Re: Project Solis —Tract J Bulk Land Plat for Mesa del Sol Innovation Park II (101605115947920604)
Project No: PR-2022-007805 (Third Submittal); SP-2025-00084
EPC Plan No: FP-2025-00004

On behalf of Project Solis, Stantec Architecture Inc. respectfully submits this supplemental submission of minor design revisions for final DFT review and approval. The proposed substitutions adhere to the preliminary approvals and findings stated in the EPC *Official Notice of Decision*, dated Aug. 21, 2025 (Plan# FP-2025-00004), and remain in full compliance with the City of Albuquerque IDO codes and regulations. The following revisions have been submitted concurrently to Mesa Del Sol ARC for Step II amendment review and approval.

Overview of Design Revisions:

SHEET NAME
**ELECTRICAL PHOTOMETRICS SITE
 PLAN**

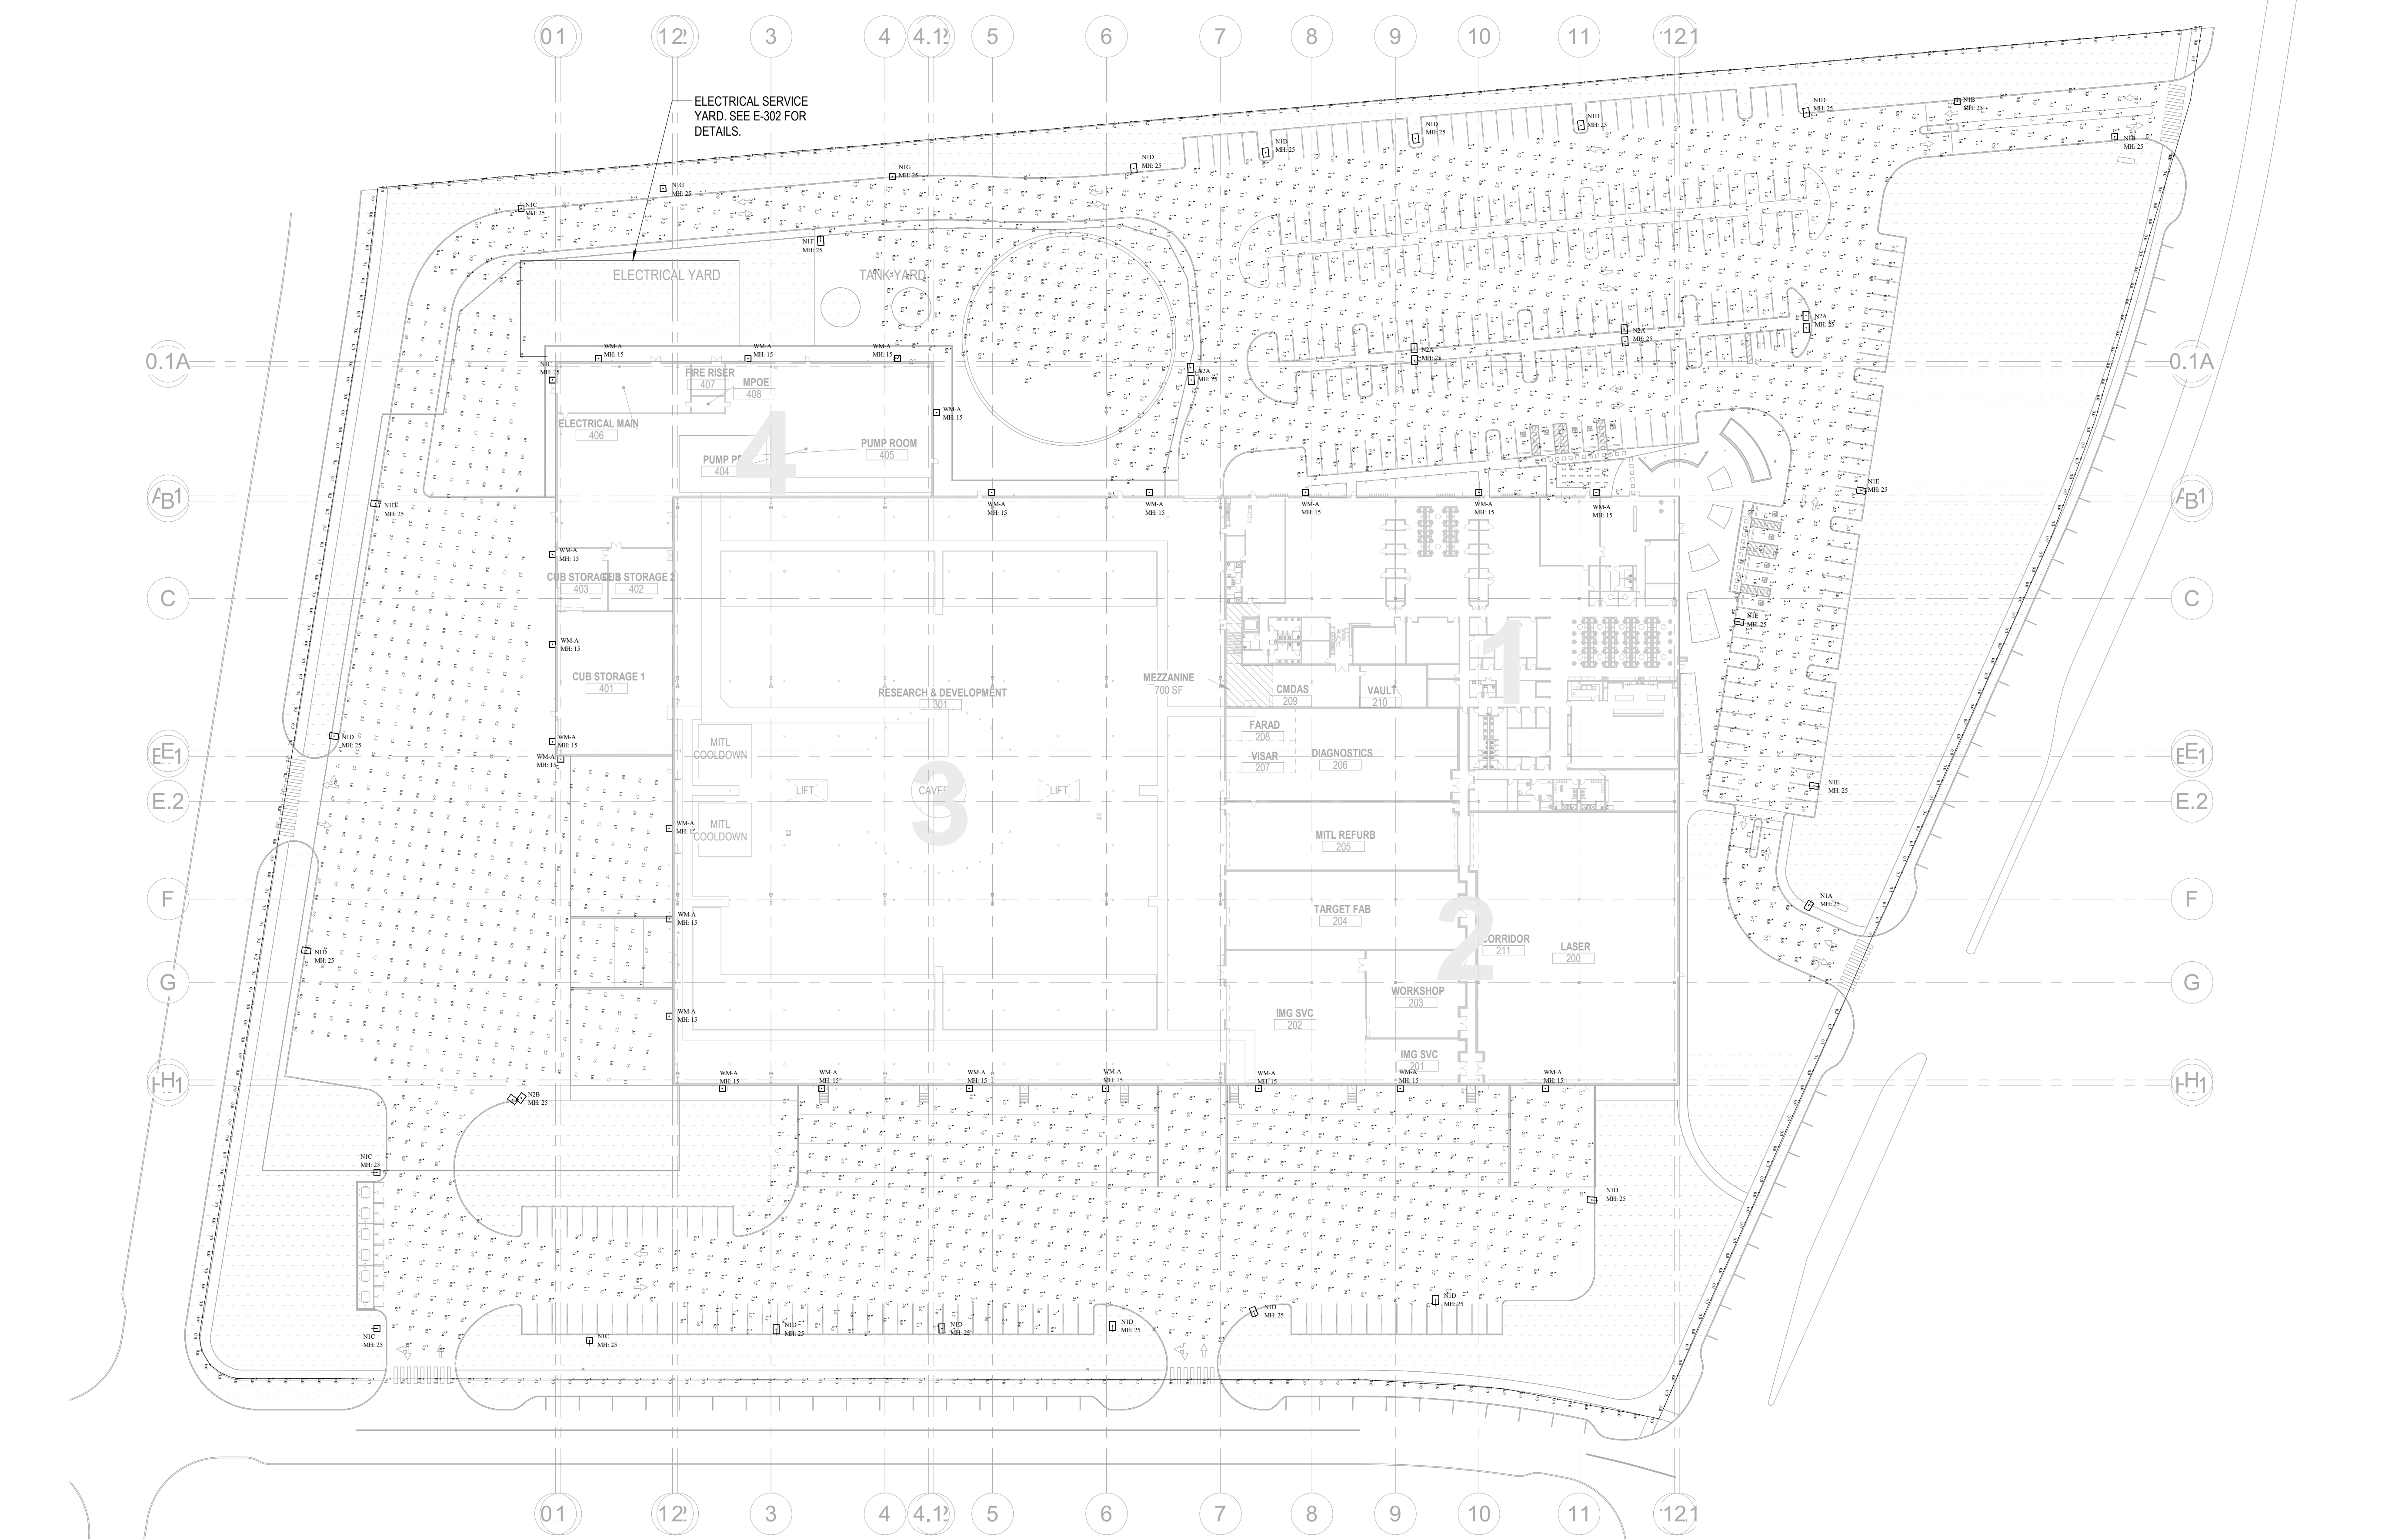
Site Lighting – The site lighting has been adjusted to match the minor modifications to the overall site design.

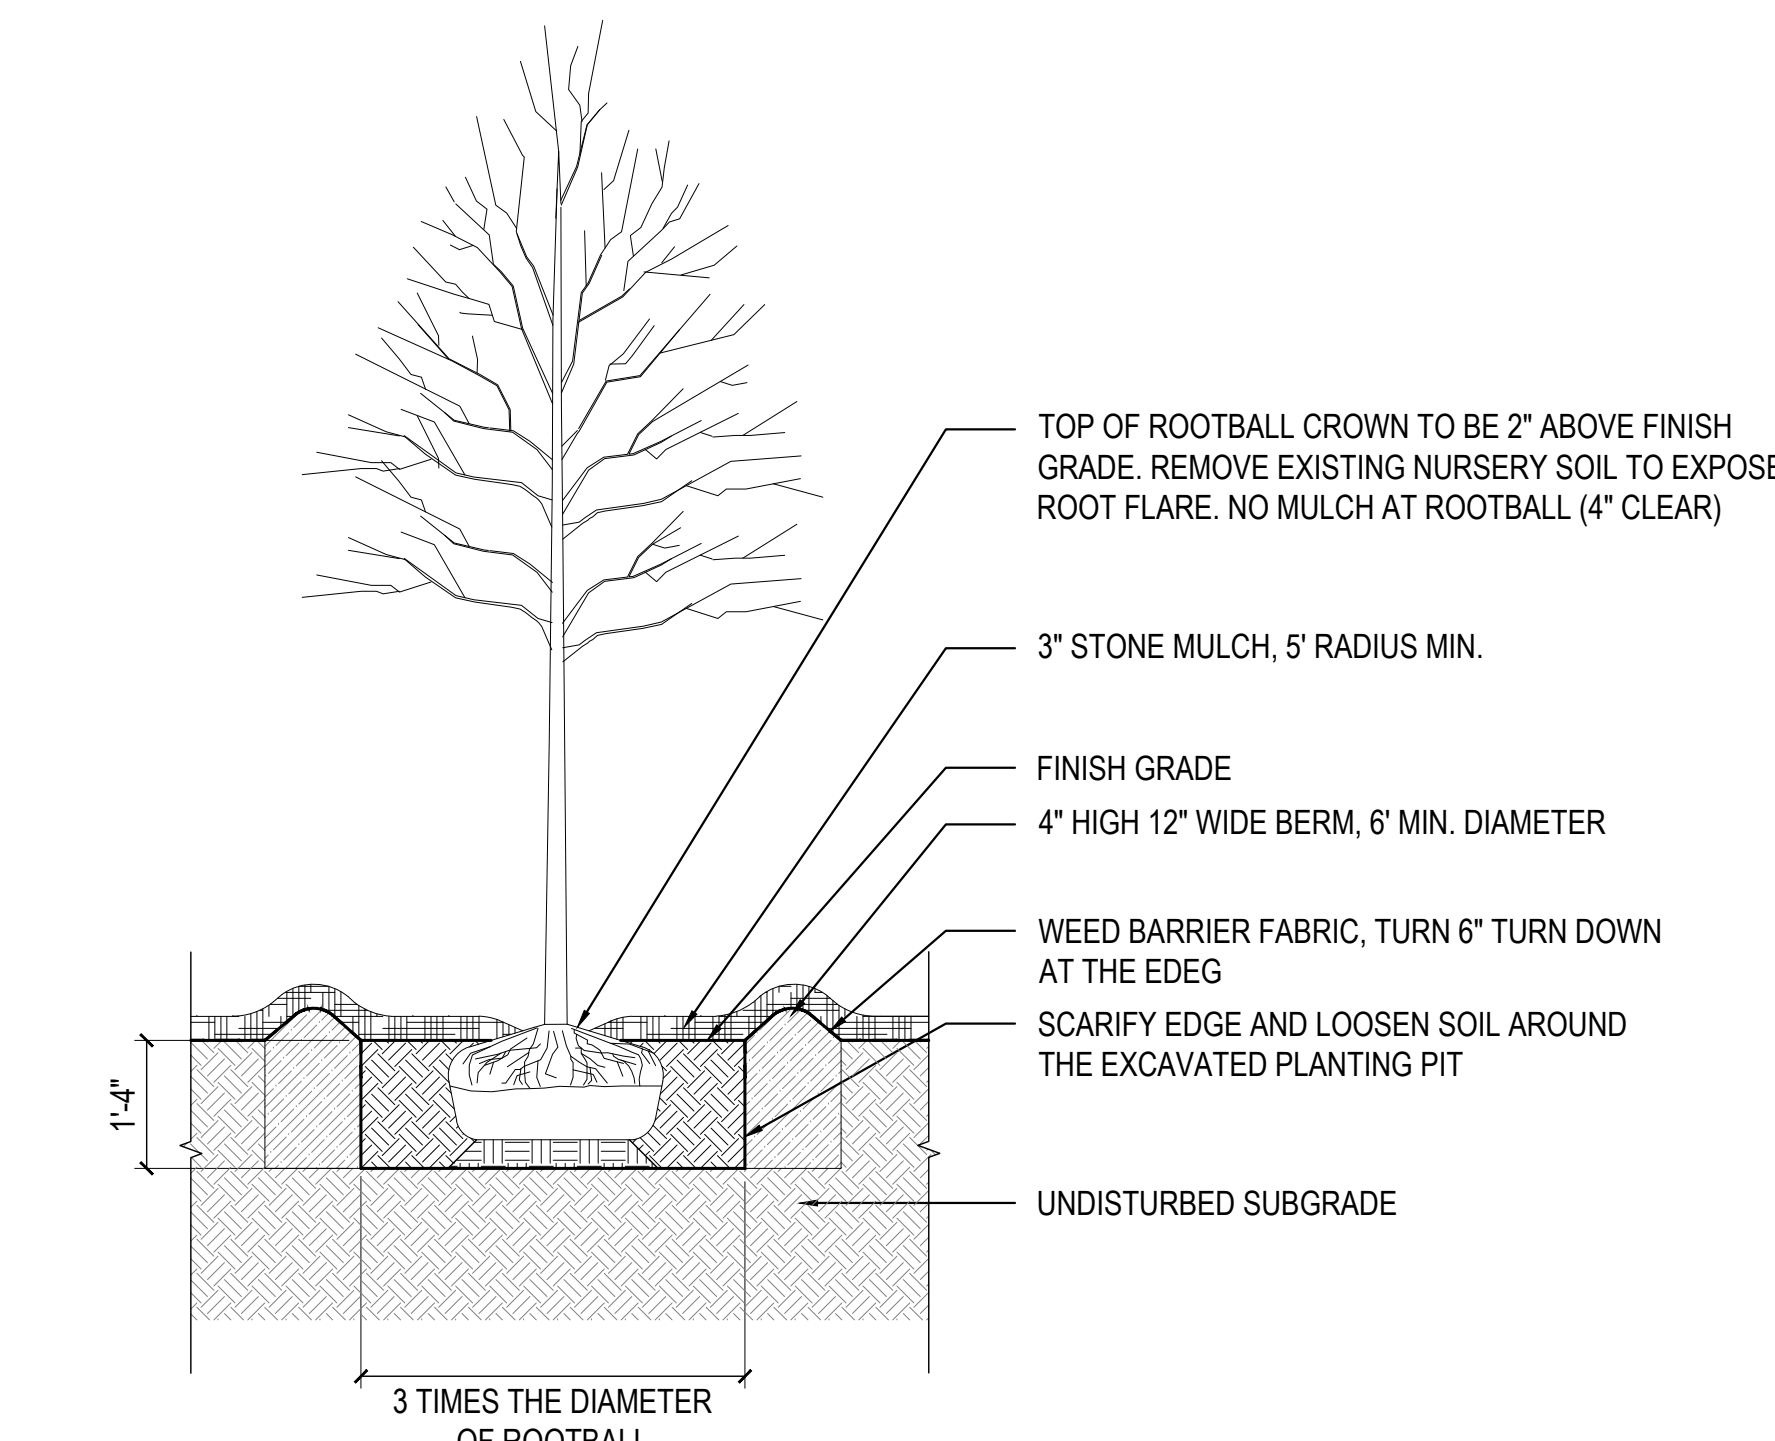
Landscape – Landscape has been reconfigured based on changes to site parking and hardscape. Plant species and coverage remain compliant with City of Albuquerque IDO standards and regulations and Mesa del Sol ARC development guidelines.
